The Drovers Solar Farm

Statement of Common Ground (SoCG) with Environment Agency (Clean)

Document reference: APP/5.13.2 (Revision 2)

DRAWING TITLE:  
ES Figure 12.16 Maximum Foundation  
Extents for Minimum Groundwater Level

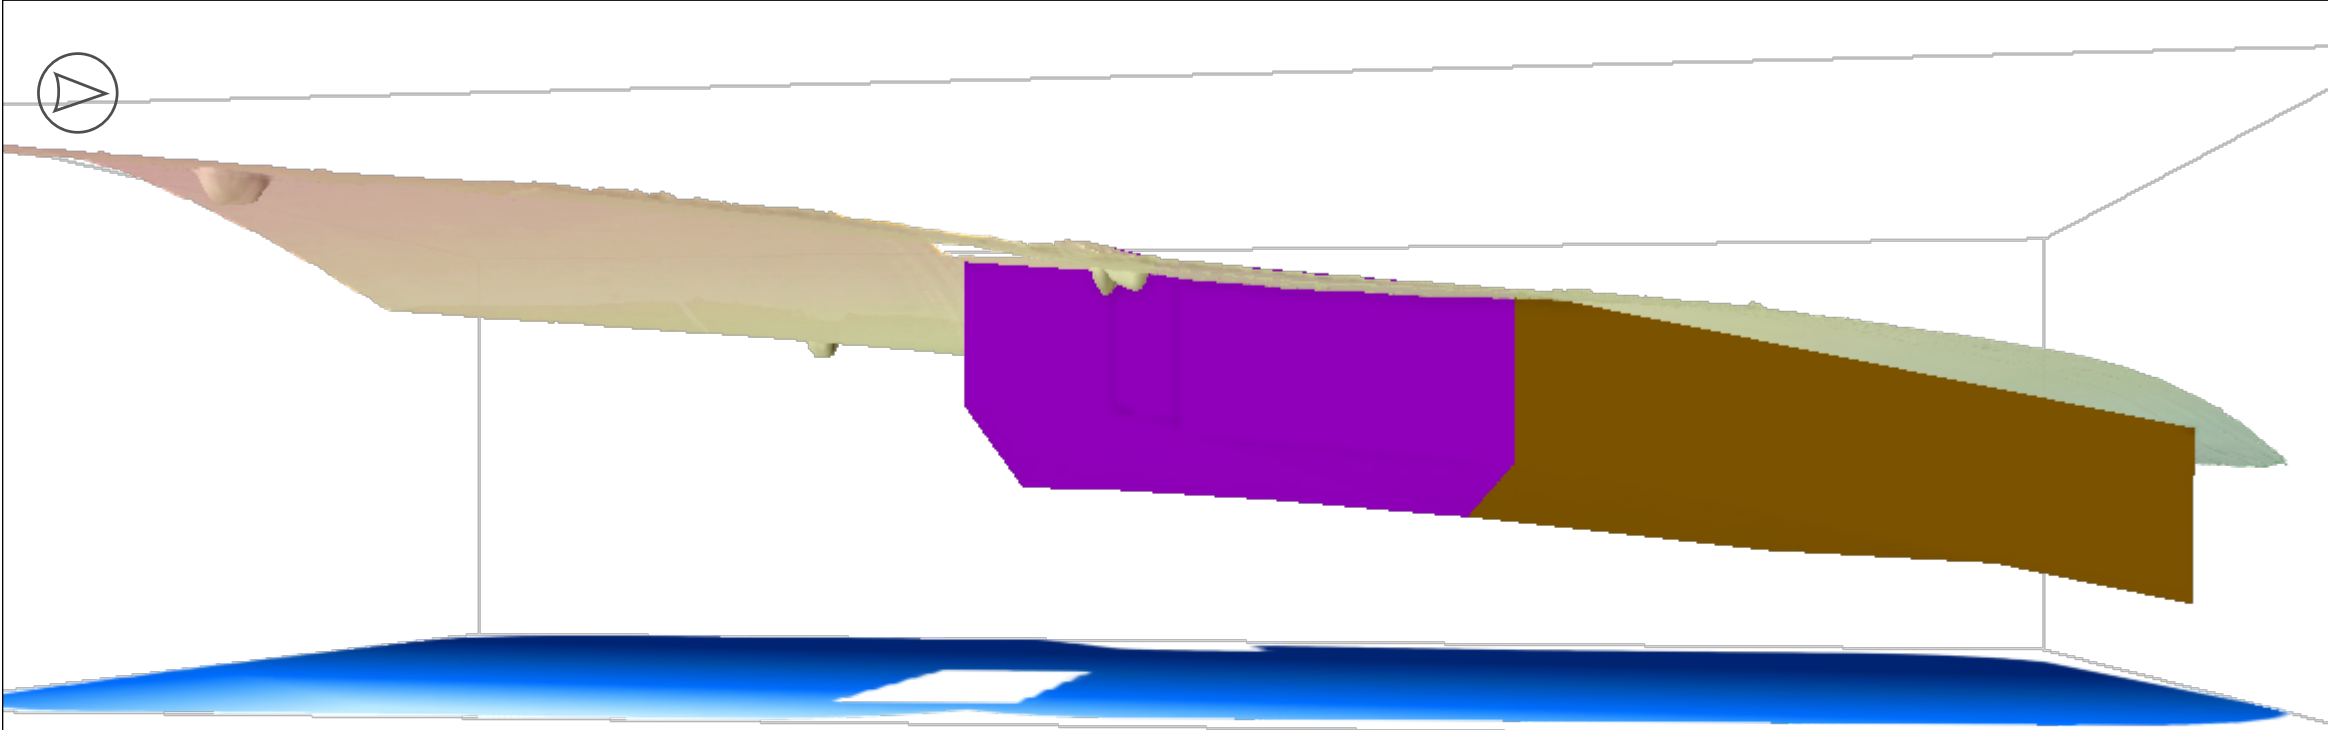
Reference	EA Issue Reference	Topic	Consultee's Position	Applicant's Position	Status
2-1	EA05	Maximum Foundation Extents	We are satisfied and consider this issue resolved. We were concerned that figures 12.13 [APP-127], 12.14 [APP-128], 12.15 [APP-129] and 12.16 [APP-130] do not clearly define the area represented by the drawings, including view orientation, or the elevation values. We have reviewed the following:	Figures 12.13 to 12.16 of ES Chapter 12: Water Resources [APP/6.2.3] were used to illustrate the maximum groundwater elevation surface across the Core Study Area and identify where proposed foundation depths could theoretically intercept shallow groundwater under worst-case conditions. The figures also demonstrate at a concept level where piling may be required depending on foundation design.	Agreed

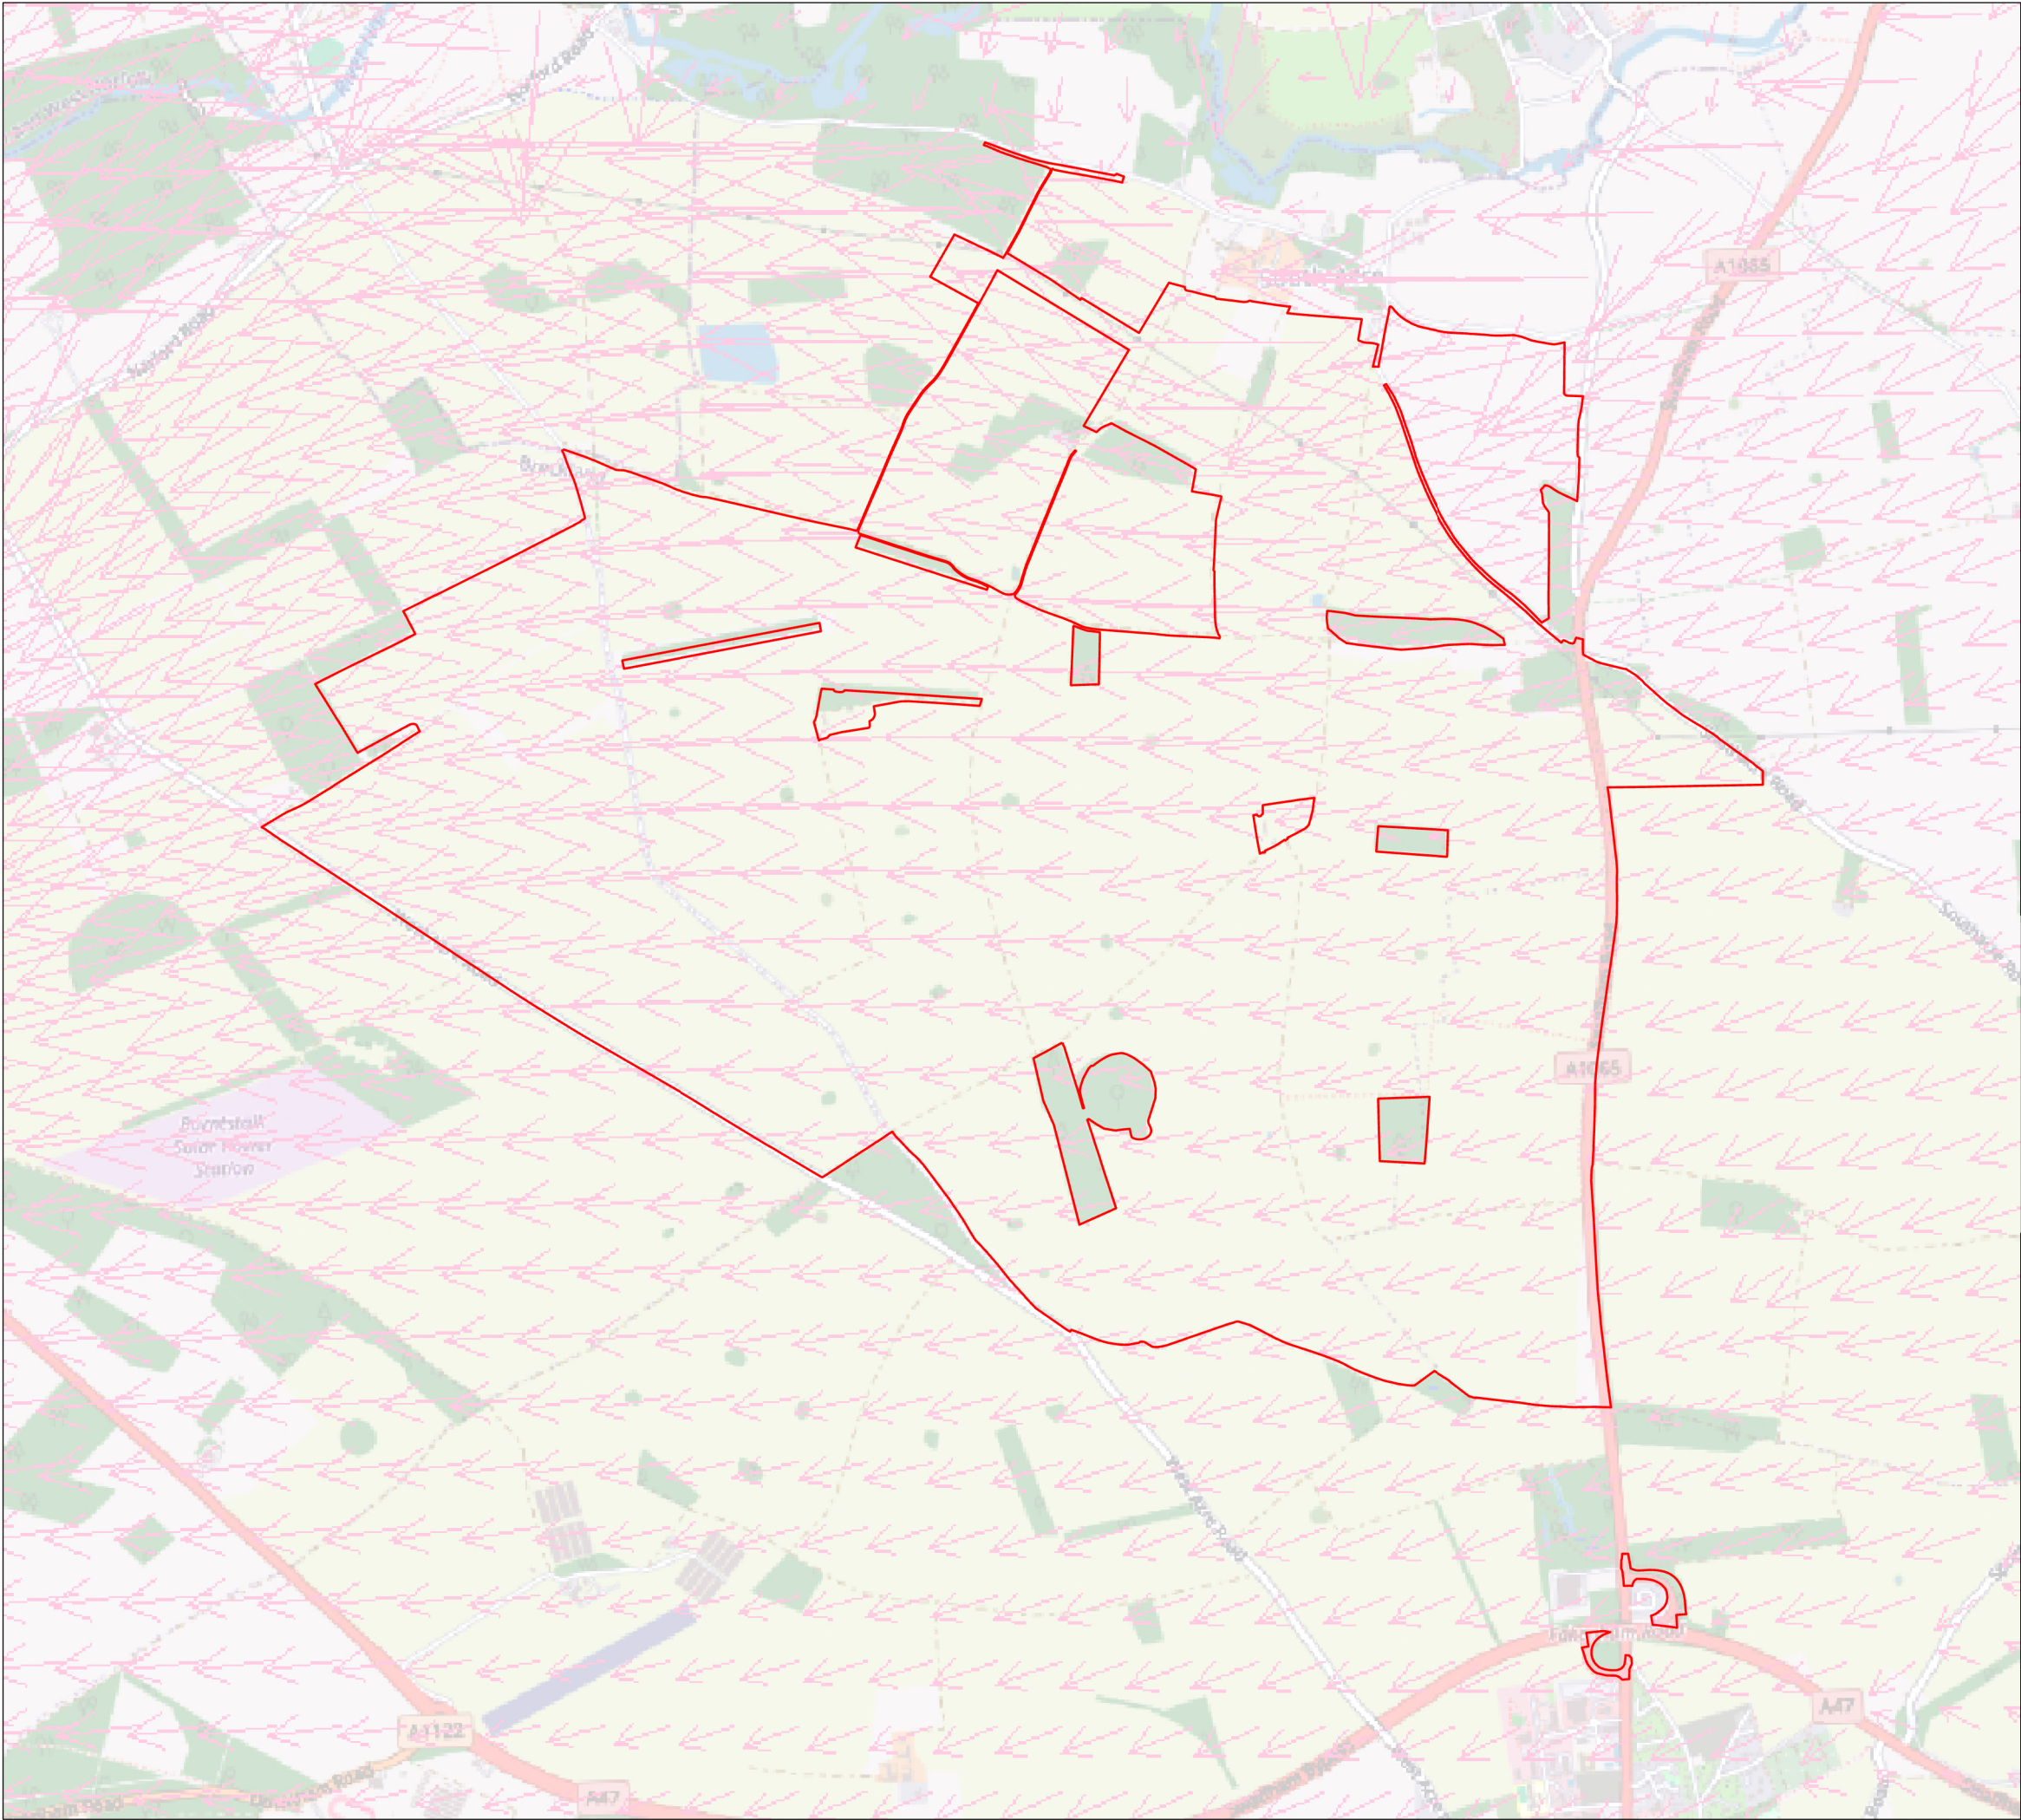
We have taken note of a number of issues with the model however. We have mentioned these below. The map shown within Figure 12.10 does appear to be the dry weather scenario output for the Chalk top layer (layer 5 of the model), rather than the wet Scenario referenced in 12.6.44 of 6.2.2 ES Chapter 12 Water Resources (Tracked) [REP3-037]. The figure linked below 6.3.1 ES Figure 12.9 Depth to NEAC Groundwater Wet Conditions [REP3-050] is not a NEAC model output (even though it is titled so). It is similar to the original 6.3 Environmental Statement Figure 12.9 Maximum Static Groundwater Level Depths within CSA [APP-123], although with levels calculated to be slightly higher to the north of the CSA than in the original figure. For the purposes of the Environmental Statement, this is sufficient, although the title of this figure should be changed to reflect where the information is derived from. Section 12.6.43 of Chapter 12 Water Resources states that the NEAC groundwater model is based on TUFLOW 5, not MODFLOW 5. The new figure 12.10 does show the correct direction, even though it is incorrectly labelled. Considering the Applicant is committed to groundwater monitoring in the 7.6.3 outline Construction Environmental

Management Plan (Tracked) [REP3-074], (table 6) this should be sufficient to mitigate risks to groundwater, now that the conceptualisation of groundwater is generally correct. We recommend the following corrections: • To either change the references to Figure 12.10 to the correct scenario (ie. Wet to Dry) or add the correct figure if available; • Change reference to the groundwater model used to create the bespoke NEAC groundwater model (ie. TUFLOW 5 to MODFLOW 5) • Correct the source for data used in Figure 12.9		
1-5	EA12	Flood Risk - BESS	We are satisfied and consider this issue resolved. We were concerned that there was insufficient flood mitigation provided for BESS units. In the 8.4 Applicant's Response to Relevant Representations [REP1-067], it is stated that the Flood Risk Assessment (FRA) includes a commitment to produce a drainage design based on the detailed site design, post DCO, based on the 1 in 100 year rainfall event + 40% climate change allowance. If localised flood depths cannot be managed by the drainage strategy, then	The Scheme has Work Nos. and does not have a detailed design at this stage. A detailed drainage plan will be provided once the detailed design of the Scheme has been progressed and finalised, following the issue of the DCO (if consented), as detailed within Section 12.4 of ES Appendix 12.2: Flood Risk Assessment [APP/6.4.4]. If localised flood depths cannot be managed via the drainage strategy, ES Appendix 12.2: Flood Risk Assessment [APP/6.4.4] was updated at Deadline 2 to confirm that BESS units will be appropriately	Agreed
